From:
To: [DCAdmin](#)
Subject: Application number 2019/90634
Date: 24 February 2020 15:35:39

Re: the above planning application we wish to comment on issues relating to the existing water supply and the drainage/sewage pipes.

client	Mr. & Mrs. R Napier
project	12 Riley Lane, Kirkburton
drawing title	Indicative Drainage Plan
drawing number	017009_103
revision	-
drawing status	Planning
scale	NTS @A3
date	10.02.2019
drawn by	-
checked by	-

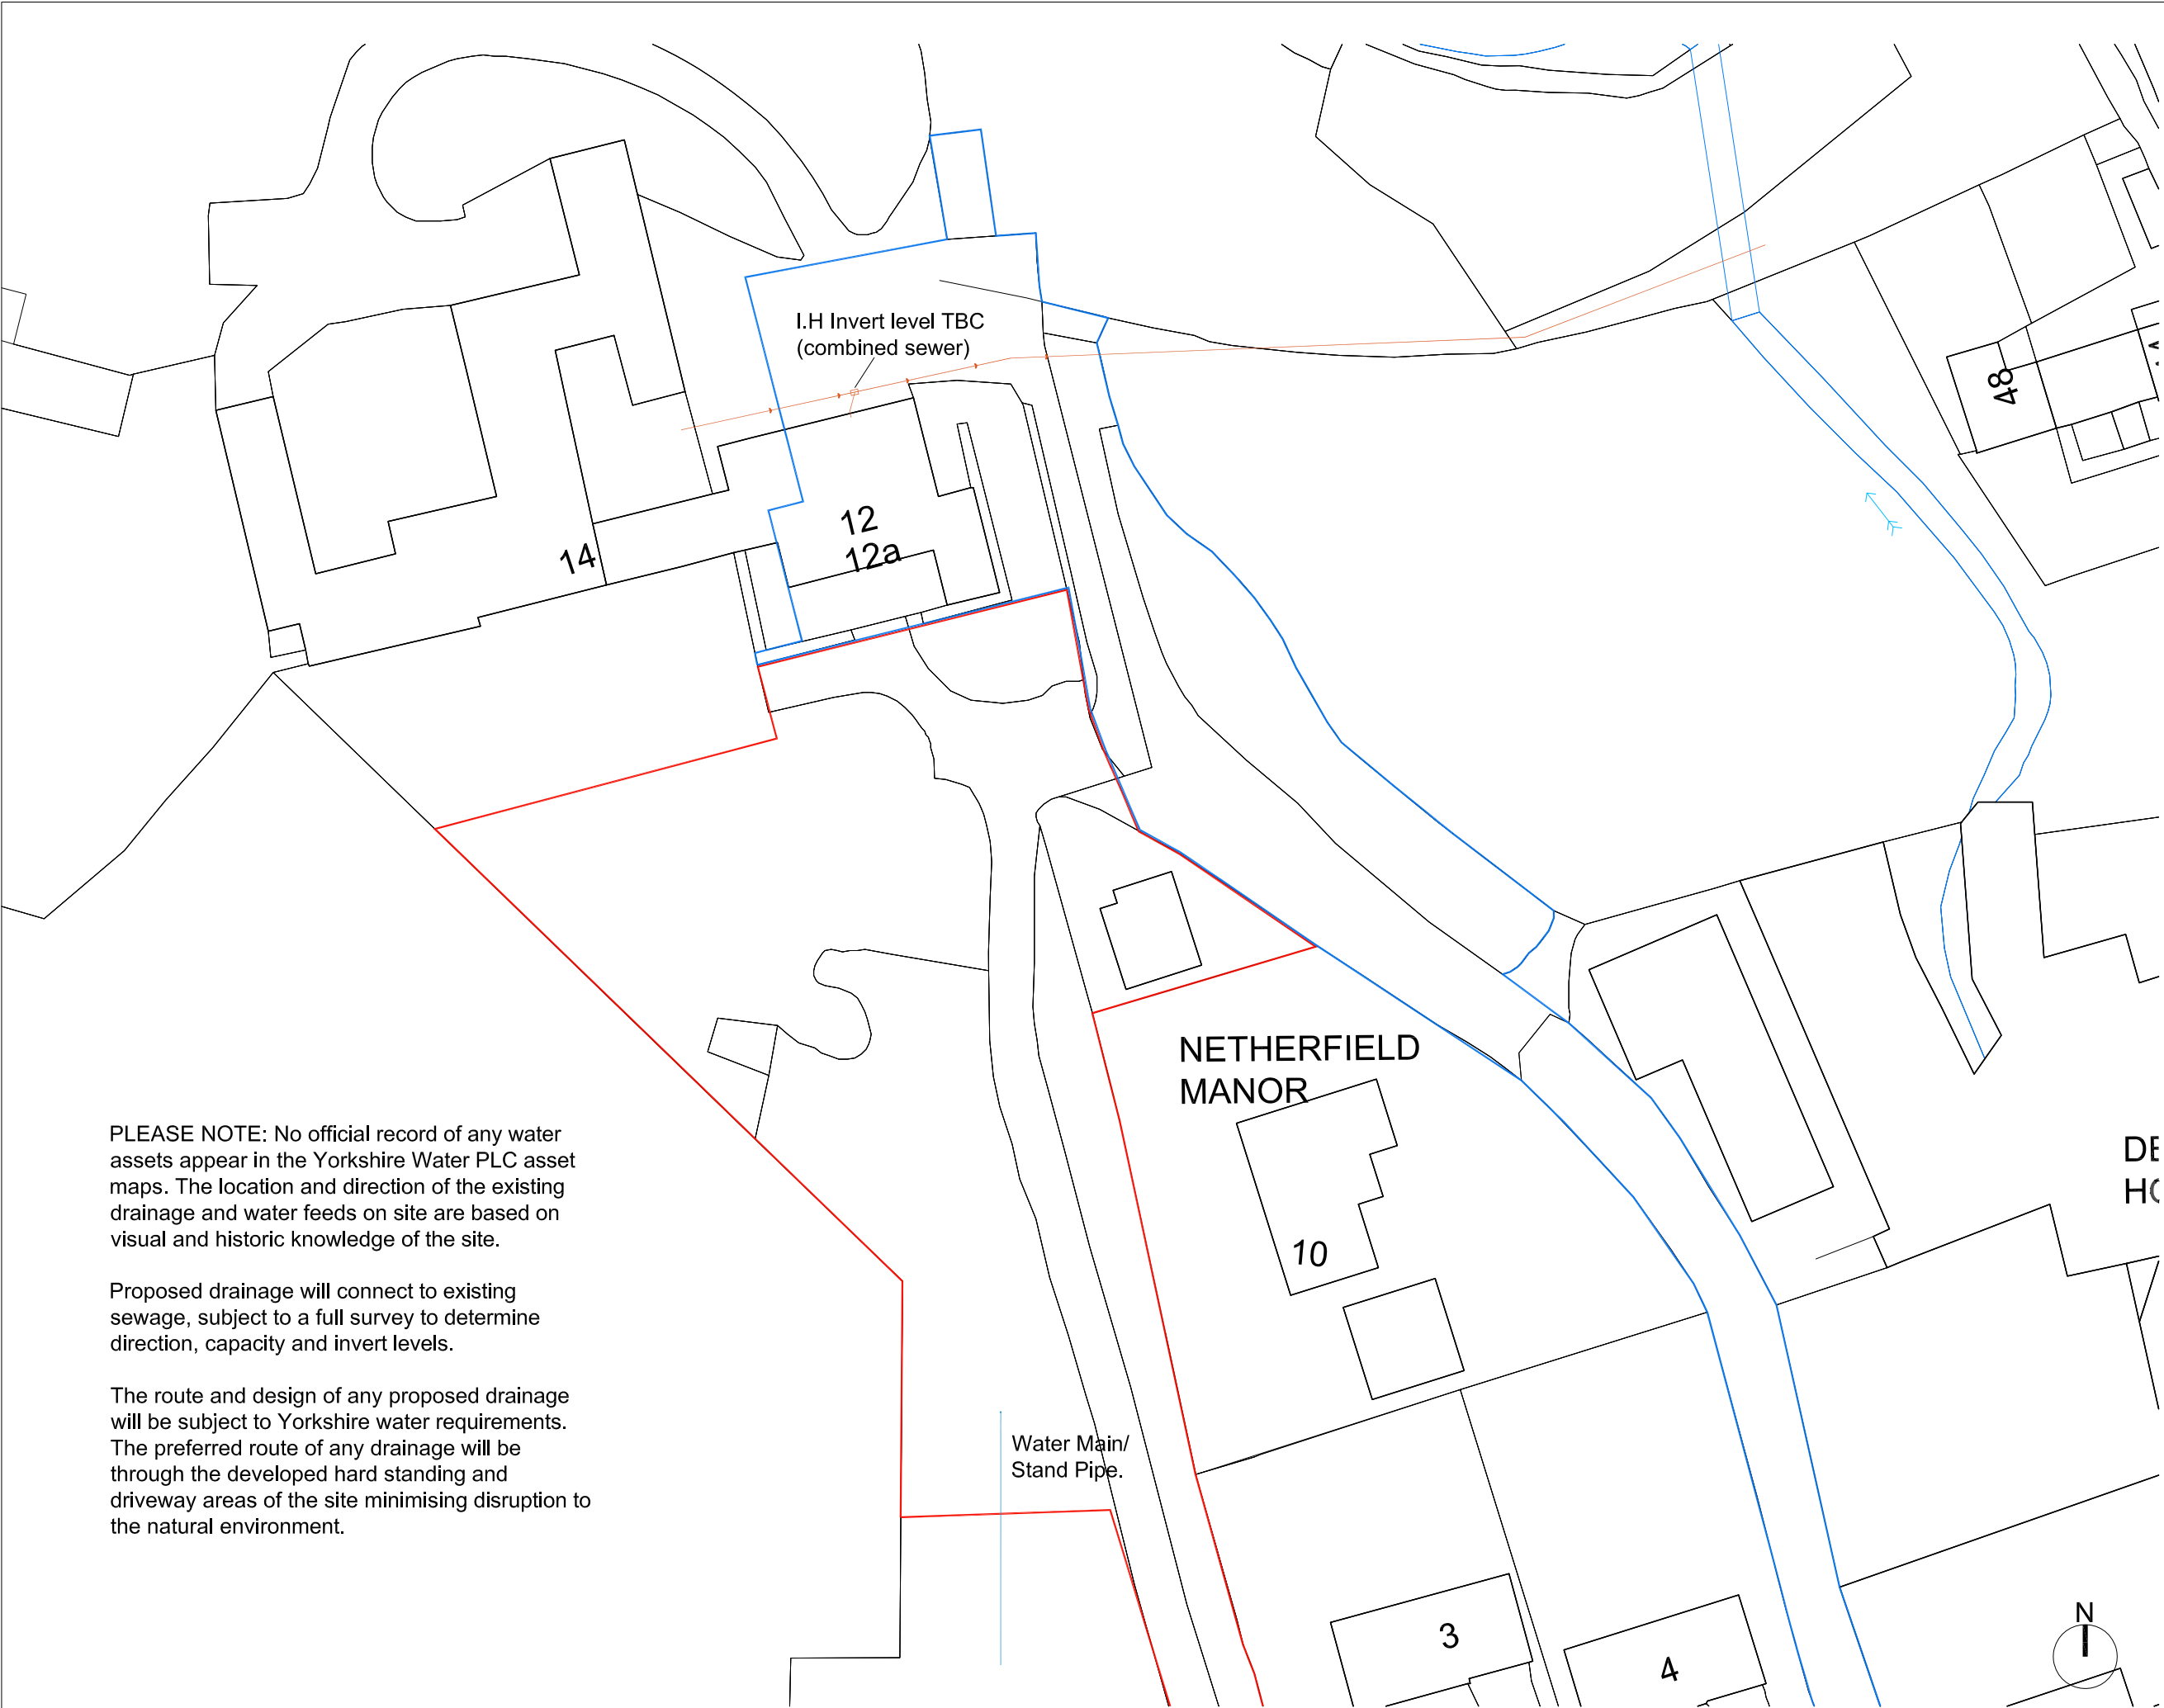
If, as you say on the plan accompanying your letter of 19 February, Yorkshire Water PLC have no official record of any water assets or of drainage/sewage direction flows or of the condition or capacities of the existing pipes, this is a matter which must be determined prior to commencement of any building on the proposed site.

We would urge that a full survey be carried out by Yorkshire Water and all other relevant services to identify the supply routes of mains water and the location of sewage disposal pipes.

It is our understanding that, currently, the mains water supply for Nos.12, 12A and 14 runs from Riley Lane through the garden of 14A (situated in Riley Lane) along the full length of the garden of No.12 (and therefore would appear to run underneath the proposed site) and then directly into our property from where it is then split into three to feed Nos.12, 12A and 14.

Given the current frequent problems with flooding at the junction of Riley Lane and the drive leading to the Concrete Grinding Company and Nos.12A and 14, we are concerned that no new building is authorised without a comprehensive survey of the above services and a reassurance that existing and/or additional mains water and drainage pipes are of sufficient standard of maintenance and capacity to have no negative impact on the existing properties.
